CITY OF ALBUQUERQUE

June 25, 2012

**Re: A Class Jumbo Storage, 5132 2nd St NW, Traffic Circulation Layout
Architect's Stamp undated (F15-D052A)**

A1.1

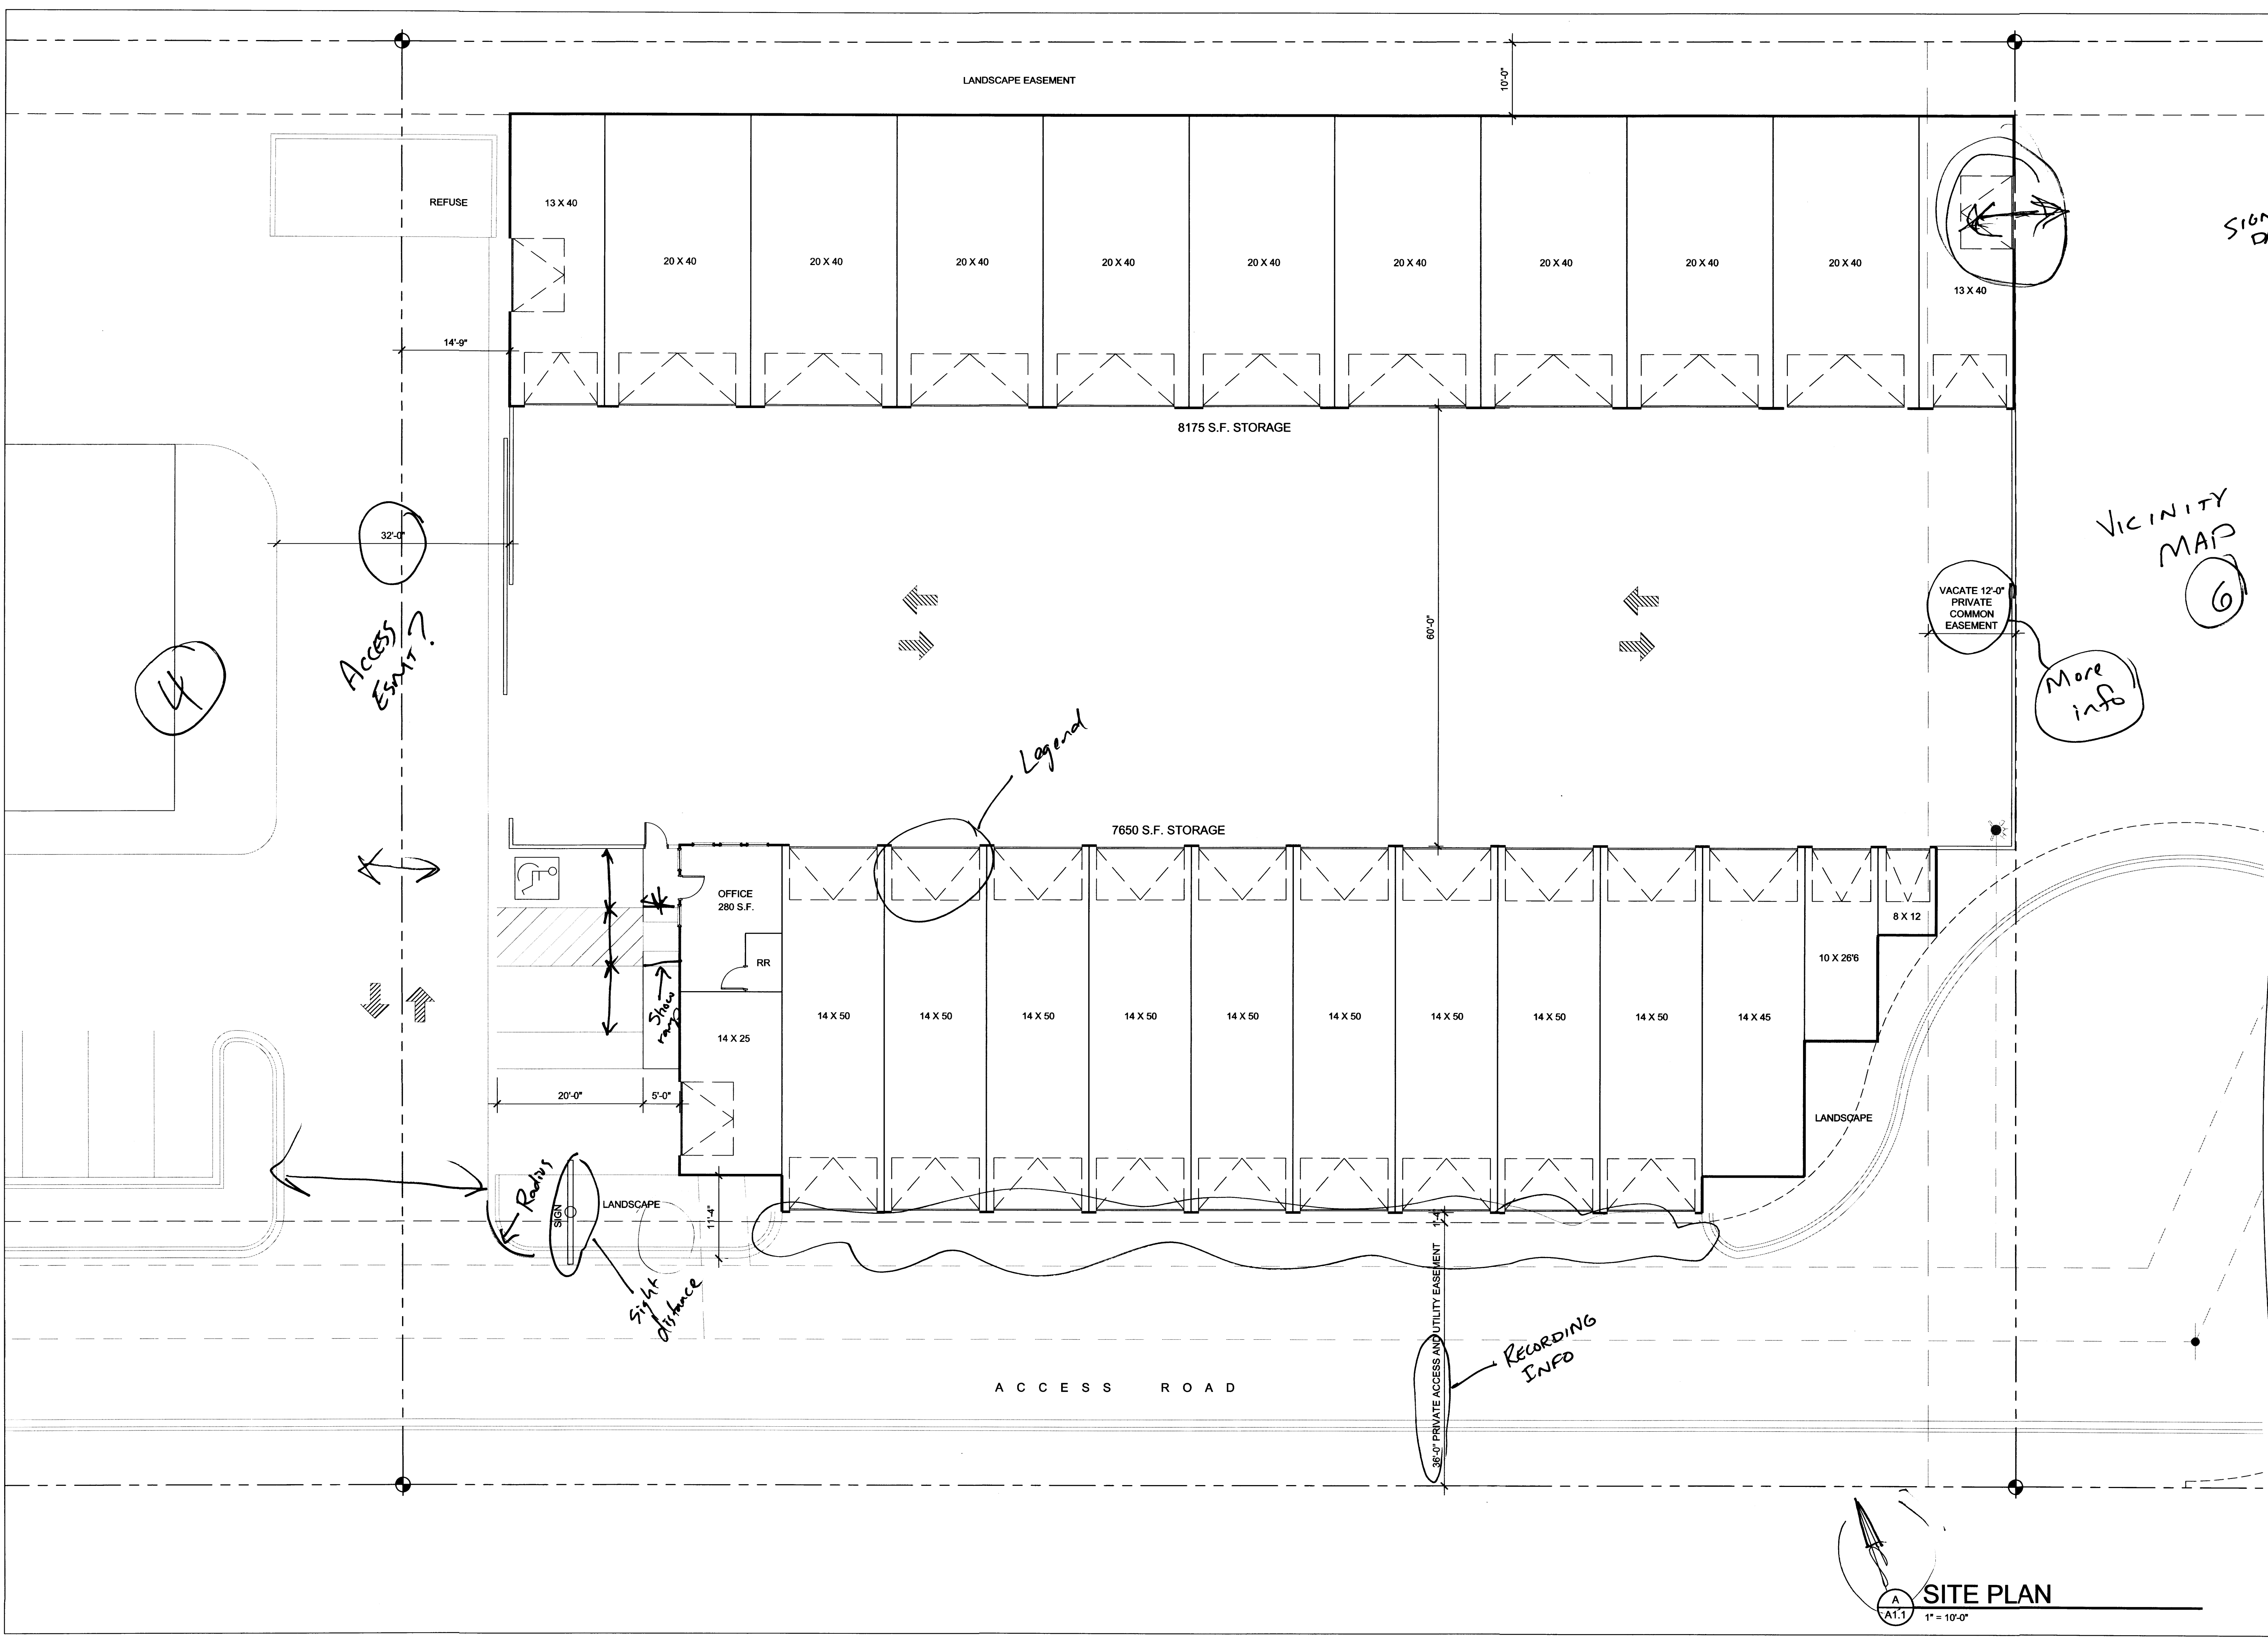
1. List radii for all curves shown; for passenger vehicles, the minimum end island radius is 15 feet.
2. Please list the width and length for all parking spaces.

3. Show all ramps and provide details.
4. Please show the location of the nearest driveway on the adjacent lot.
5. List the number of parking spaces required by the zoning code as well as the proposed number of parking spaces.

6. Please show a vicinity map.
7. The handicapped spaces must include an 8-foot wide van access aisle; all other aisles should be 5 feet in width.
8. Define width of the existing sidewalk.

9. Show all existing sidewalk and wheelchair ramps. Provide geometric information.
10. The traffic circulation layout must be stamped, signed, and dated by an engineer or architect licensed in the state of New Mexico.

11. List the width of the existing drivepad.
12. Please include two copies of the traffic circulation layout at the next submittal.
13. All easements must be clearly defined. Provide the recording information.

14. How will the existing hydrant adjacent to lot 6 be protected?
15. An easement is shown adjacent to lot 6. Please define the purpose and extents of the easement. The easement must be vacated prior to permitting a structure to be built over it.

16. How will vehicles accessing the storage units adjacent to lots 4 and 6 maneuver? Access is shown from these units to the adjacent lots; is there an access easement?

17. Access to the southern storage units from the private roadway is not permitted, as the curb cut would exceed City of Albuquerque standards for width and would interfere with pedestrian movement. Please revise.
18. The proposed sign may interfere with the sight distance of the driveway. Please provide a sight distance exhibit (see the *Development Process Manual*, Chapter 23, Section 6, Part B.12).
